**West Yorkshire Police
Kirklees District**

Designing Out Crime Officer

To: Richard Gilbert Kirklees Council Planning Services Civic Centre 1, High Street, Huddersfield, HD1 2NF	Ref: 2021/90800 Date: 10 January 2022
--	--

**Site Location: Hinchliffe Mill, Water Street, Holmbridge, Holmfirth, HD9 2NX
Application Type: Residential Dwellings**

BOUNDARY TREATMENTS

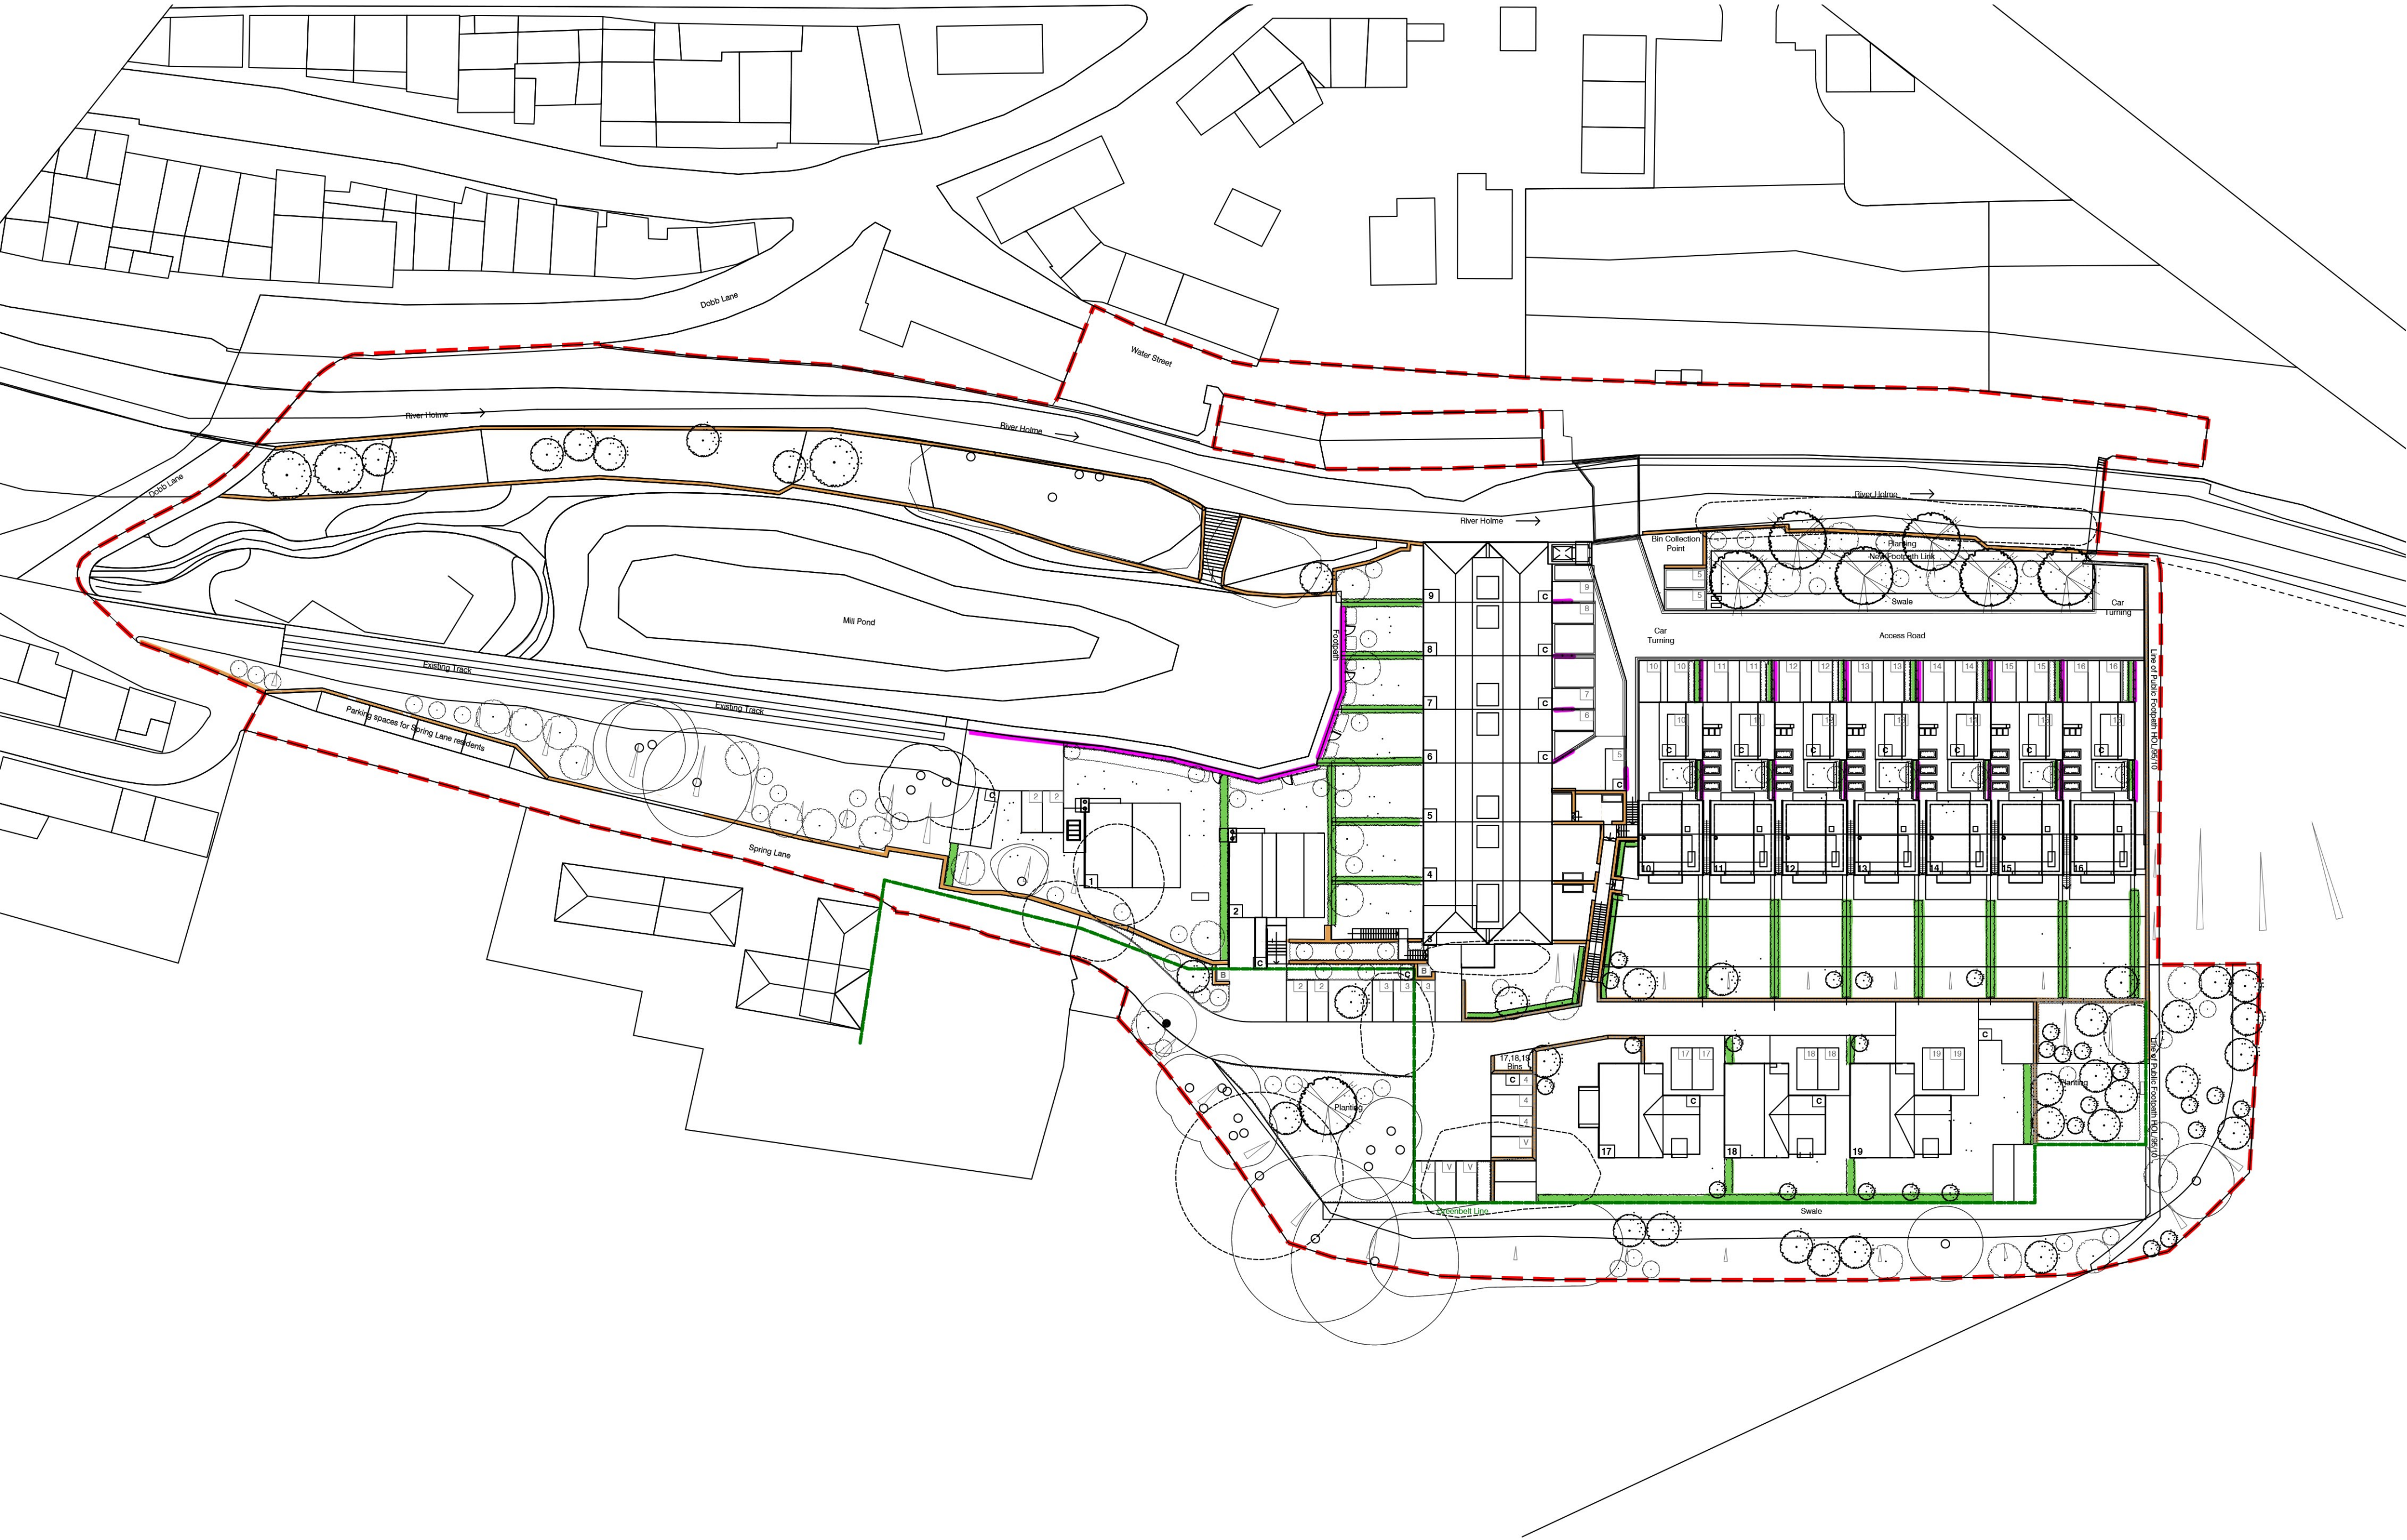
It is recommended the rear boundary treatments for each plot are to a height of 1800mm such as masonry materials, close boarded timber fencing or other durable materials. Rear plot dividers in height of 1800mm consisting of the same material as above should be installed between properties.

Access must be restricted from the front of each plot into the rear garden by installing a 1800mm high lockable gate. This gate should be positioned near to the front building line to eliminate recesses and to increase natural surveillance restricting unauthorised access.

All external facing boundary treatments **MUST** be smooth faced with no footholds or cross members to enable climbing access.

Plots with open front gardens, should have a marked boundary that clearly distinguishes the private space of the garden, from the public space outside it. This should consist of hedge / low wall / fence / railings of around 1m in height.

Plot dividers need to be tall and substantial enough to provide both privacy and security. Closed boarded timber fencing should be provided to a minimum 1.5m in height, and include privacy screen (a section of higher fencing) of 1.8m in height projecting out from the building for about 2m, to provide a private amenity area adjacent to the home.

Gates to the side of the dwelling that provide access to rear gardens or yards must be robustly constructed, be the same height as the fence (minimum height 1.8m) and be capable of being locked (operable by key from both sides of the gate). Such gates must be located on or as near to the front of the building line as possible.
